State of Washington
DEPARTMENT OF FISH AND WILDLIFE
South Central Region • Region 3 • 1701 South 24th Avenue, Yakima, WA 98902-5720
Telephone: (509) 575-2740 • Fax: (509) 575-2474

RE: WDFW Comments on VA-23-00003 Sparks Park

Thank you for the opportunity to comment on the Variance Application for Sparks Park (VA-23-00003). Washington Department of Fish and Wildlife (WDFW) has reviewed the application and supporting documents. WDFW did comment as well on the original application and our comments are similar here. We would like to highlight a few issues relating to the project's potential impact on fish and wildlife habitat.

PRELIMINARY SITE PLAN
 MOUNTVIEW GROUP LLC TRAVEL CENTER
 WEST SPARKS ROAD
 EASTON, WASHINGTON

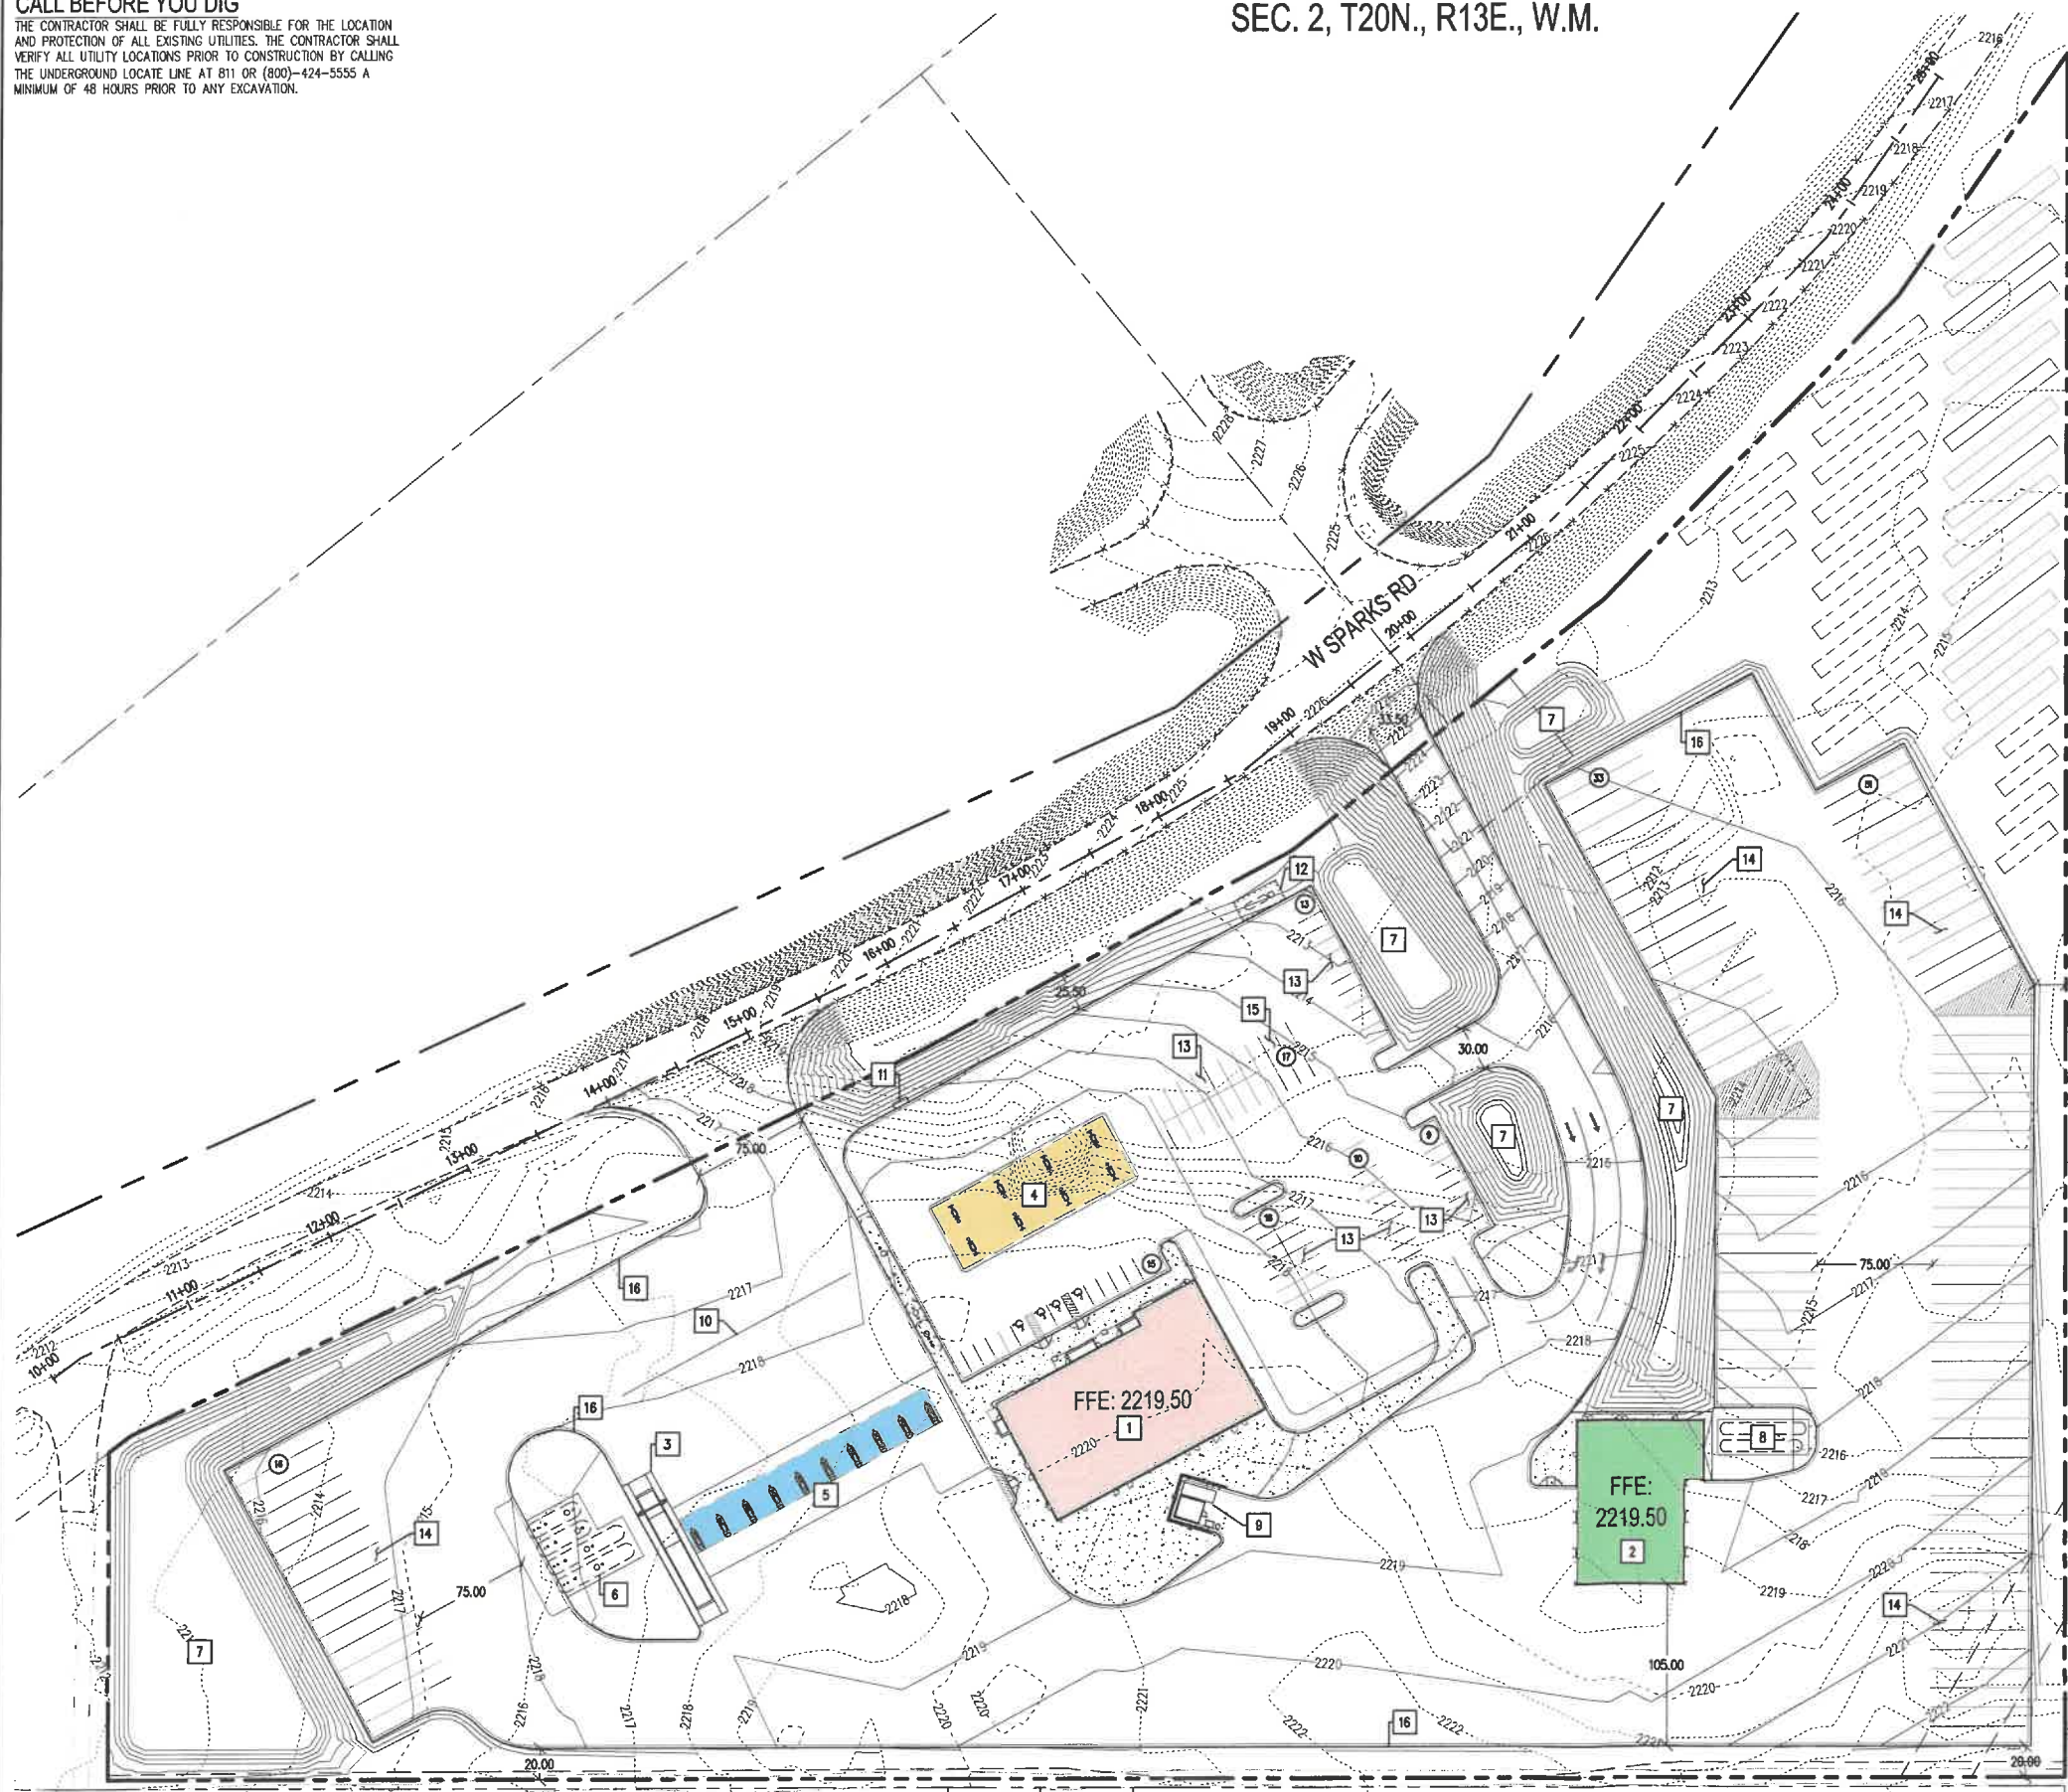
1. The project area is located with an Elk Winter Concentration Area. With the substantial amount of proposed clearing, WDFW offers up a few suggestions to minimize the habitat impact and offset the impacts.

- a. WDFW requests that the clearing limits be restricted to only the absolute minimum needed to build the proposed truck stop
 - b. Revegetation for temporary impacted areas, be revegetated with native vegetation from the area to help offset any losses of forested habitat. If the applicant has questions or needs help in suggesting how to replant for native vegetation and/or avoid some of the forested area, WDFW would be willing to assist from a habitat point of view.

- c. To offset habitat impacts, WDFW would like the applicant to consider donating some of the cleared trees to nearby habitat projects. WDFW can assist in coordinating those discussions.

2. With the amount of vegetation removal and increased impervious surface in a high snowfall area, a detailed drainage plan needs to be conducted to show that drainage from the site can be properly dealt with and not contribute to the degradation of nearby fish-bearing waters such as Lake Easton and Silver Creek. WDFW requests the ability to review and comment on the drainage plan once it is complete.
